**WELWYN HATFIELD BOROUGH COUNCIL  
ASSISTANT DIRECTOR (PLANNING)**

**DELEGATED APPLICATION**

**Application No:** 6/2022/2478/LB  
**Location:** 44 Fore Street Hatfield AI9 5AH  
**Proposal:** Replacement of 8 x rear facing windows and provision of 2 extractor vents at the rear of the site  
**Officer:** Ms Kirsty Shirley

Drng. No
 894 / 02

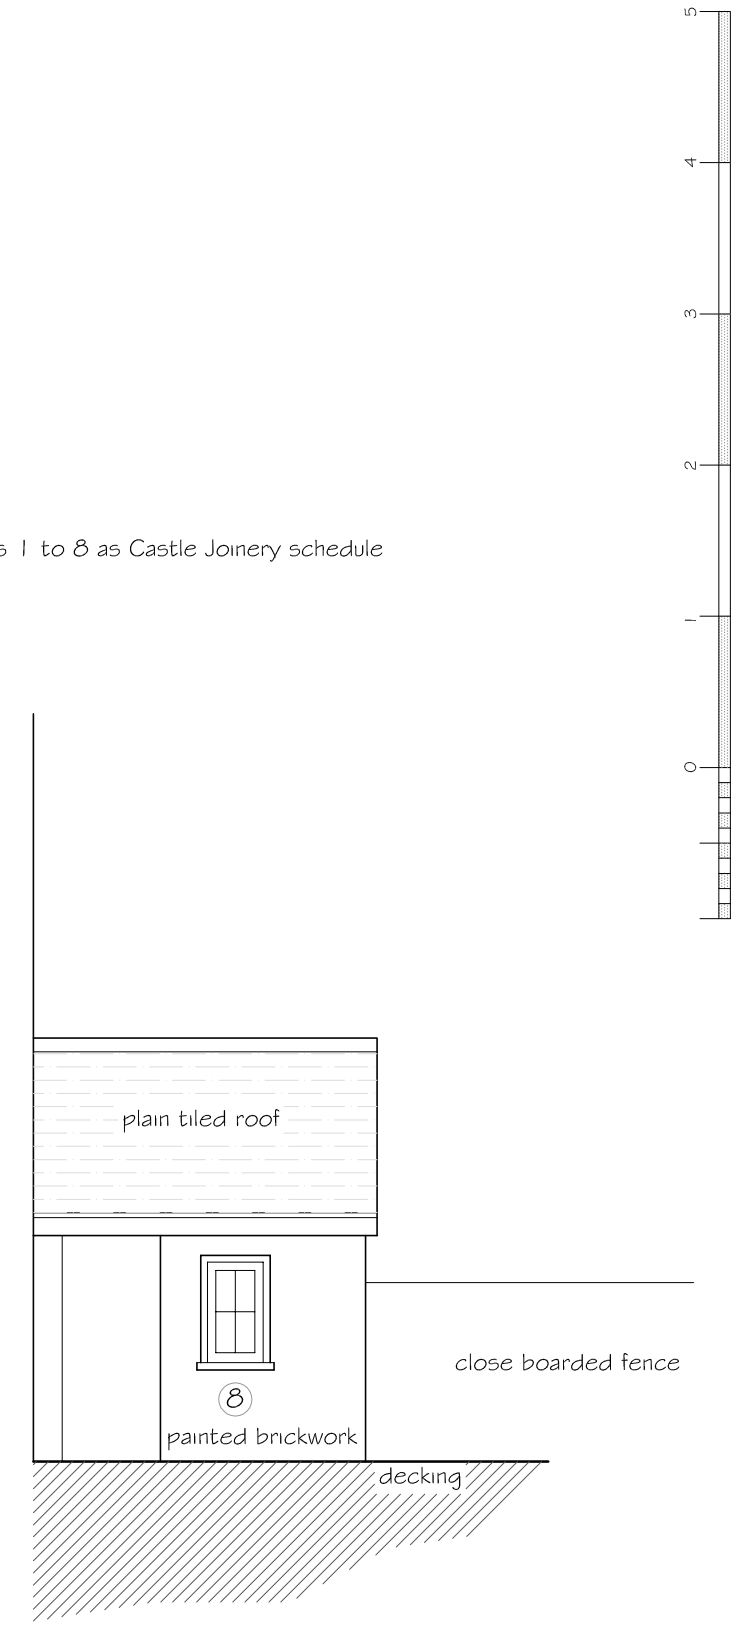
<p>small-scale changes that lead to a cumulative loss or harm to the significance of the asset or historic environment should be avoided.</p> <p>The proposal is for the replacement of eight rear facing windows and installation of two extractor fans within the rear elevation.</p> <p>The rear windows are all modern replacements of various periods and quality with no windows of significance in the rear elevation. The proposed replacement windows have traditionally detailed timber frames and double-glazed units. As per Historic England's guidance on <i>Traditional Windows: their care, repair and upgrading</i> (2017) the replacement of modern, poorly detailed windows with traditional well detailed double-glazed windows is acceptable as the improvements in the design and detailing of the windows enhance the appearance of the building.</p> <p>The submitted information shows flush fitting side hung painted wood casement windows proposed for all windows with the exception of the second-floor window serving the bathroom window (annotated as window 1) which would be a sliding sash window. The windows are traditionally designed without trickle vents and the double-glazing units would be approximately 15mm in thickness and will improve the sound and thermal insulation. Submitted details also show integral glazing spacer bars with a putty finish. The spacer bars and glazing putty should be white to improve the appearance of the windows. Materials of the development can be secured by condition.</p> <p>Two extractor vents are proposed to be installed at first and second floor level on the rear elevation. The proposed extractor fans would result in minor loss of historic fabric.</p> <p>The proposed works would enhance the special interest and significance of the listed building and are considered to be compliant with Chapter 16 of the NPPF and Section 16 of the Planning (Listed Buildings and Conservation Areas) Act 1990. The works also enhance the significance of the Conservation Area, as per Section 72 of the 1990 Act.</p>

1. The approved development shall match the existing window casement in terms of colour with the casements of the windows constructed of timber and the glazing spacer bars and glazing putty shall be white in colour unless otherwise agreed in writing with the Local Planning Authority.
